Technical Note

Project No: ITB13091
Project Title: Ford Airfield – The Landings
Title: Highway Safety and Network Capacity
Ref: ITB13091-030 TN
Date: 21 July 2020

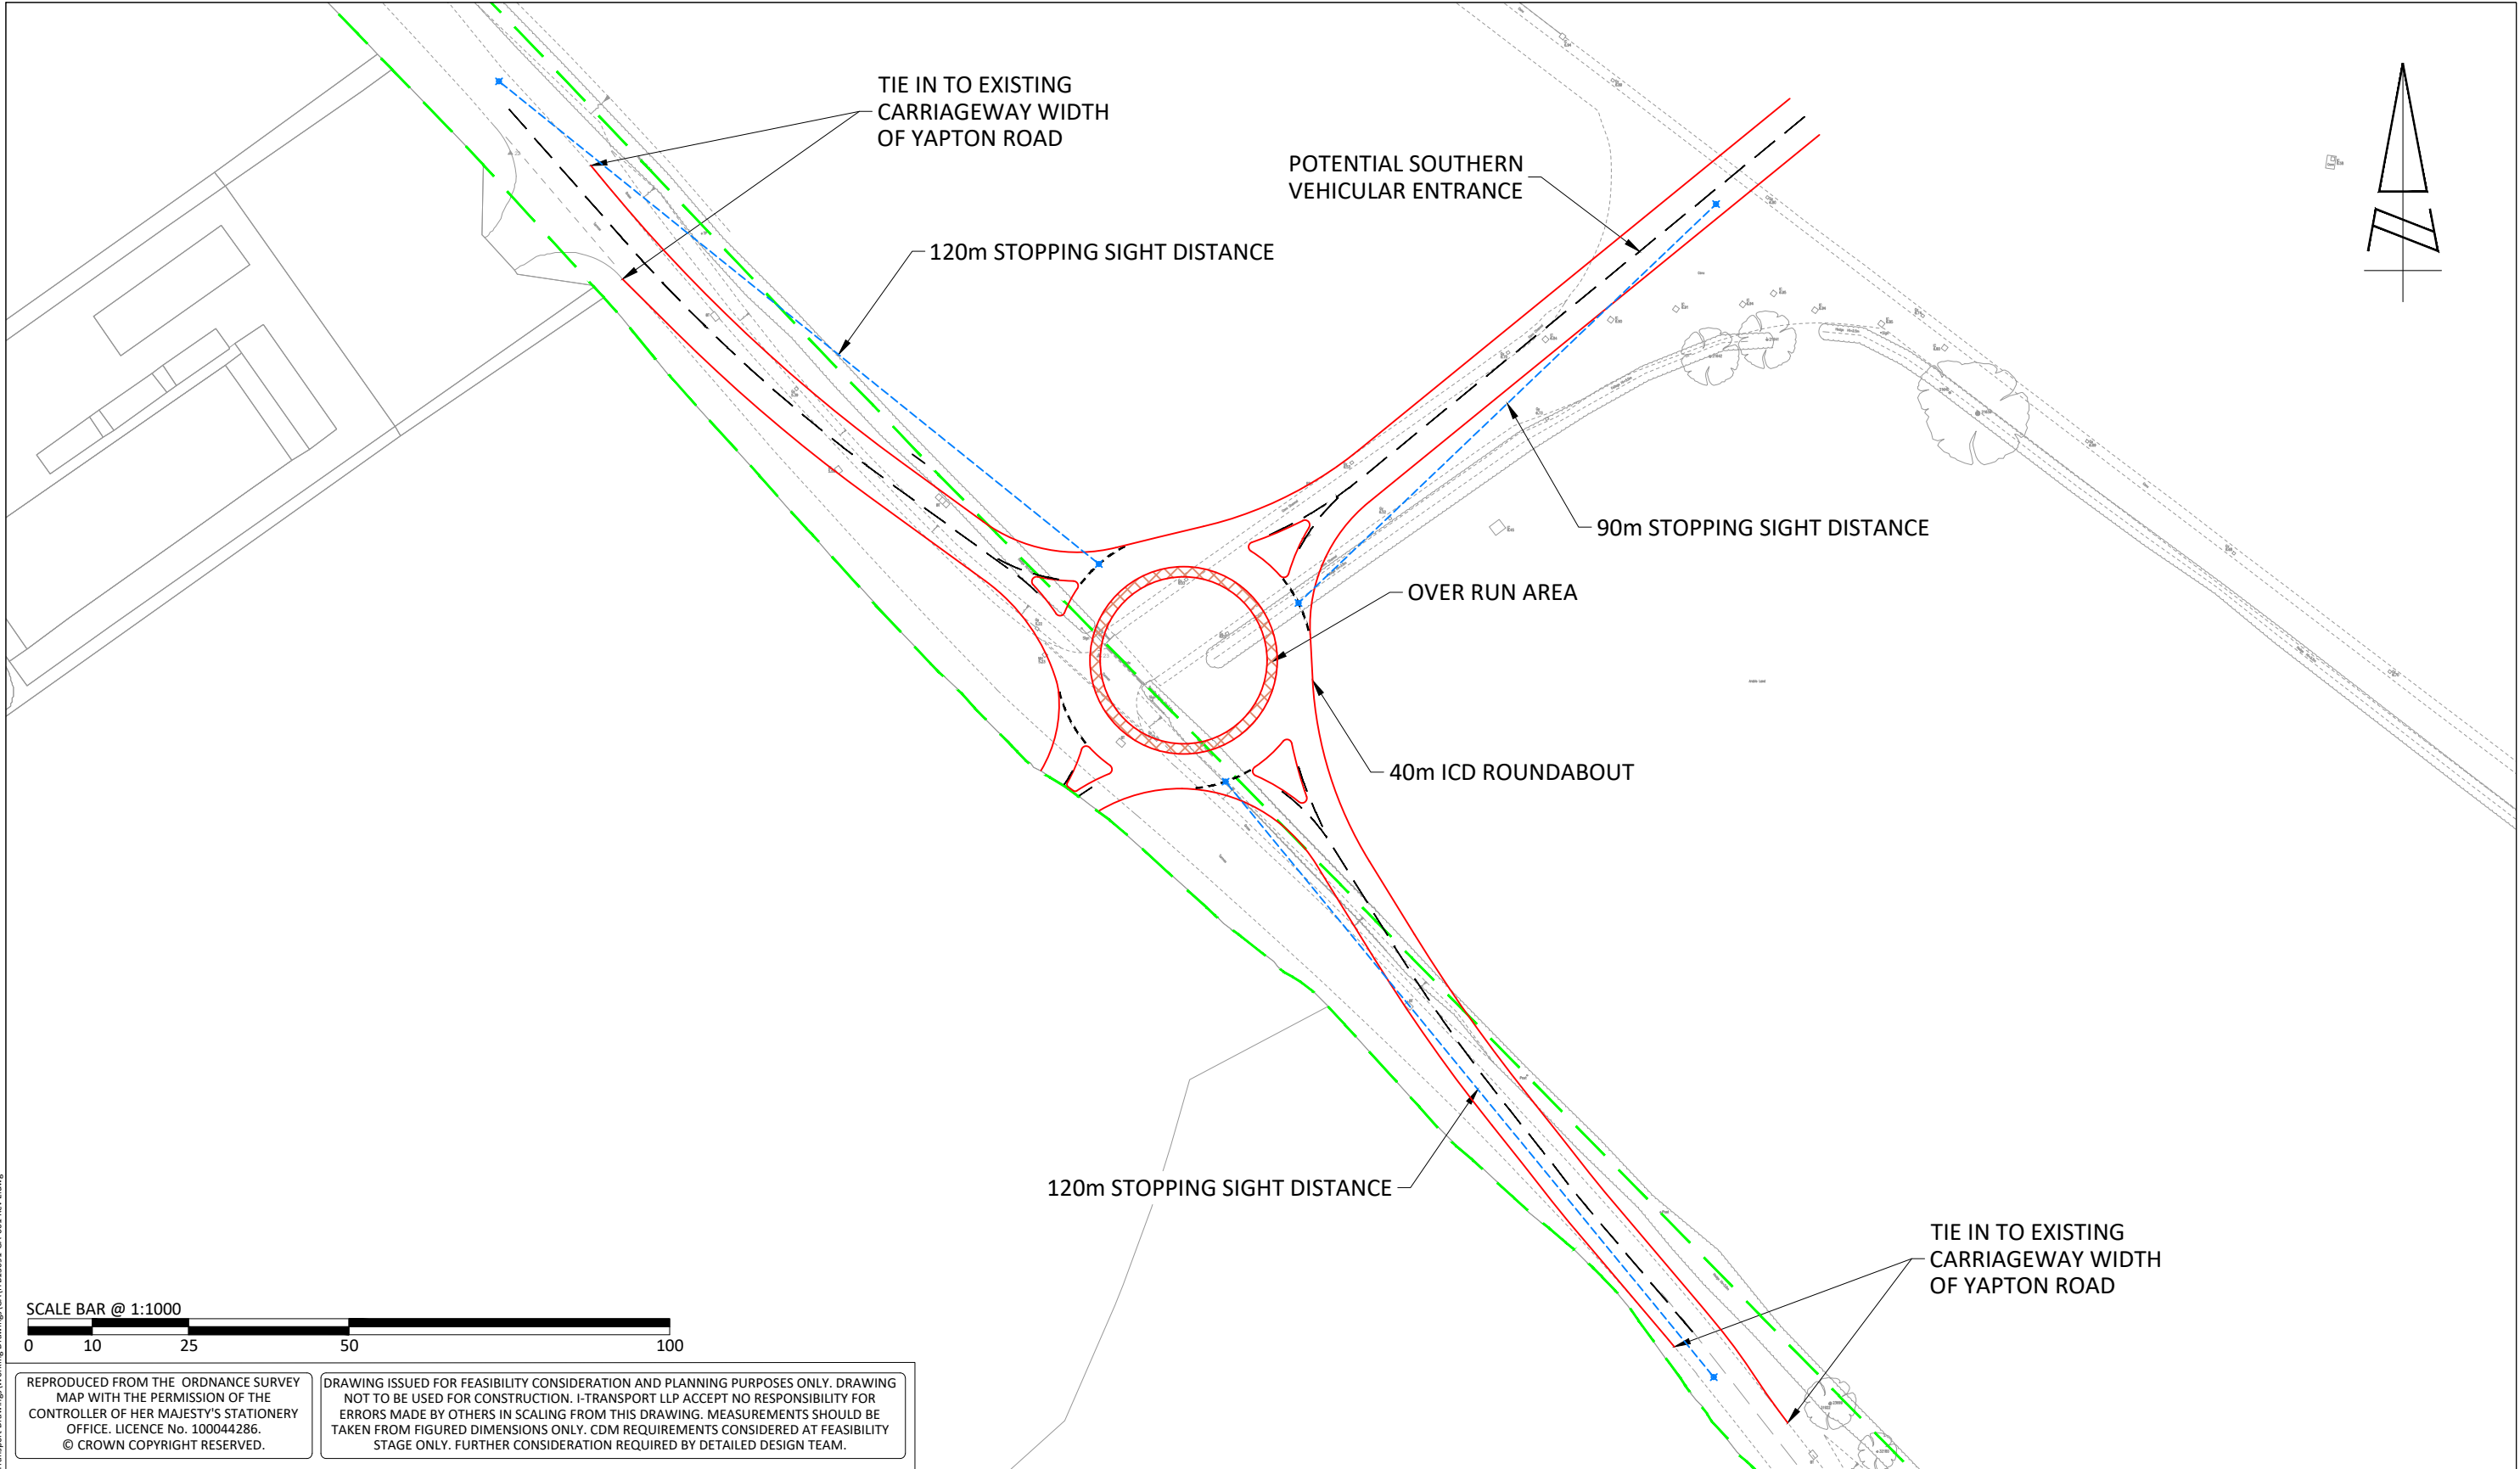
- 2.1.1 WSCC has sought clarification on the proposed site access roundabout onto Yapton Road, in particular, to confirm the dimension of the Inscribed Circle Diameter (ICD) and whether contact has been made with the landowner regarding the proposed access arrangements to the retained agricultural land west of the roundabout.

- 2.1.7 On this basis, it can be confirmed that the roundabout is to be provided as a 40m ICD 4-arm roundabout, as presented in **Drawing ITB13091-001 Rev E**, an extract of which is provided in **Image 2.1**. No further modelling of the roundabout has been undertaken, given that it has been satisfactorily demonstrated a smaller 28m ICD roundabout operates within capacity in all assessment scenarios; a larger roundabout will operate with greater capacity.

- 2.1.8 It can also be confirmed that the landowner has been consulted through the design process and is satisfied that the proposed roundabout arrangement provides suitable and appropriate access to the retained agricultural land for vehicles associated with continuation of existing operations.

T:\Project\13009 Series\1309-11TB Ford Airfield\Tech\Acad\Transport Drawings\Working Drawings\GA\ITB13091-GA-006.dwg

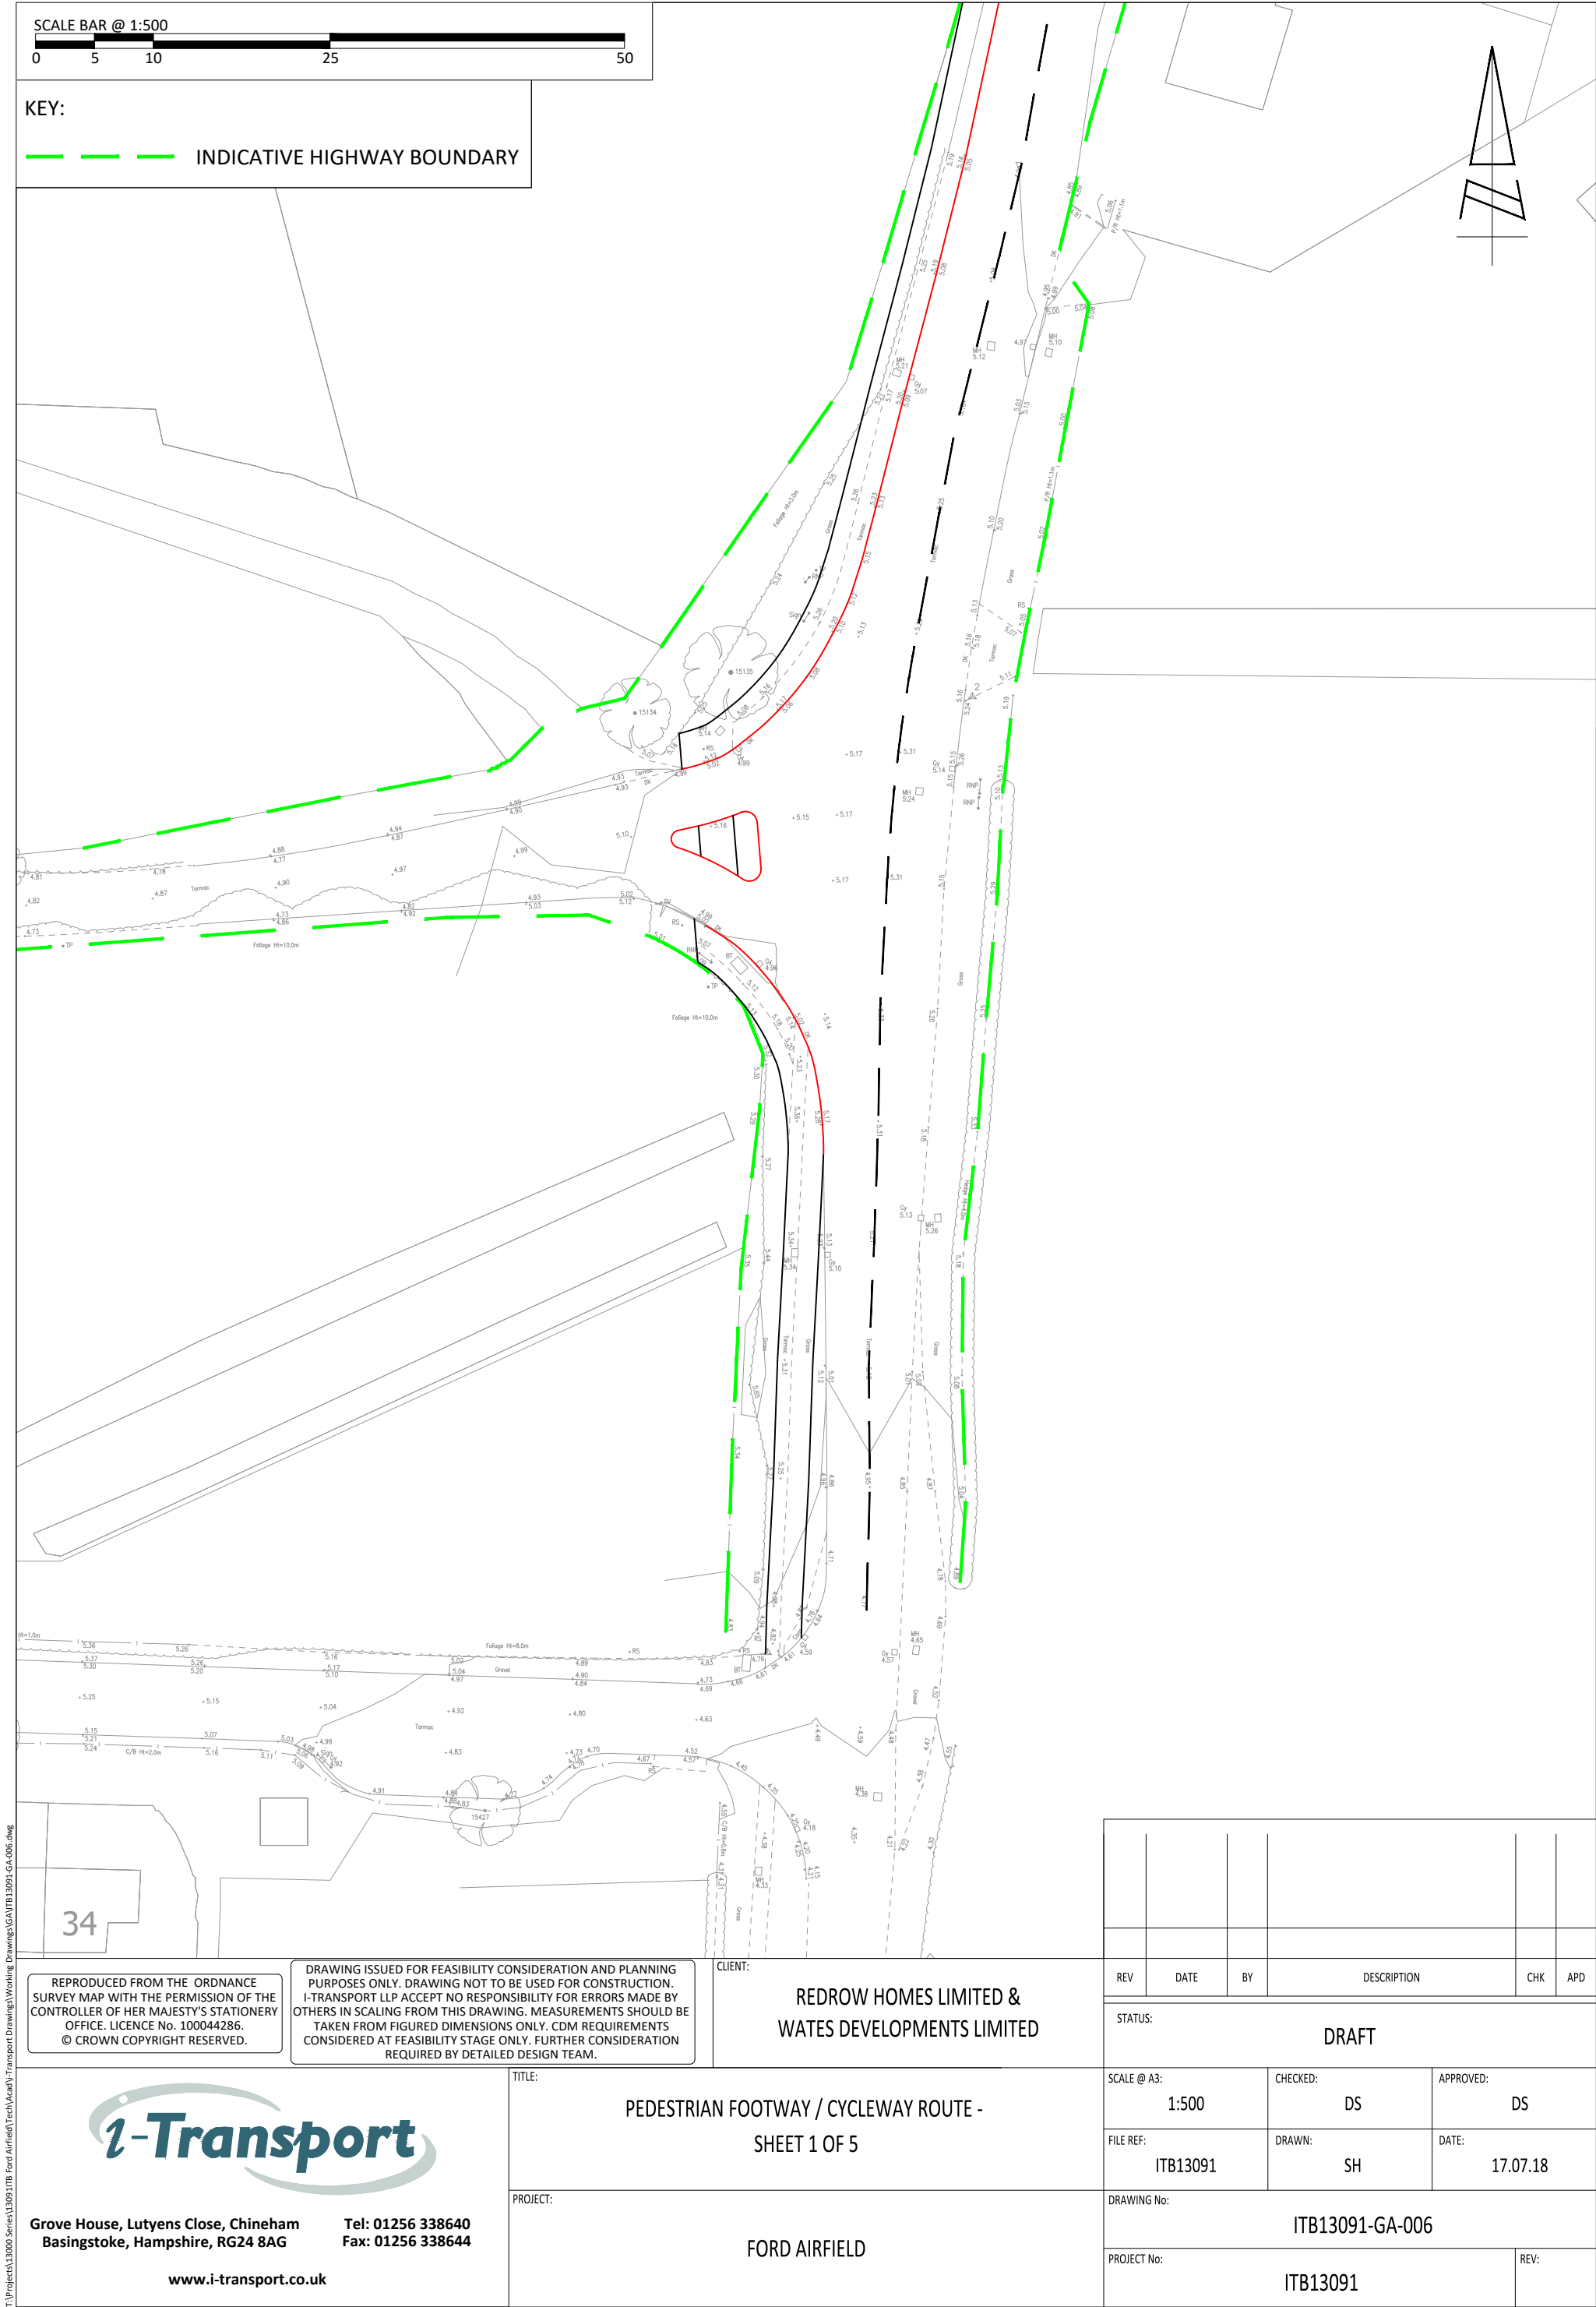
4.2.1 WSCC has requested that the modelling parameters used in the assessment of this junction be provided on a plan. The parameters are shown on **Drawing ITB13091-GA-006 Geom**.
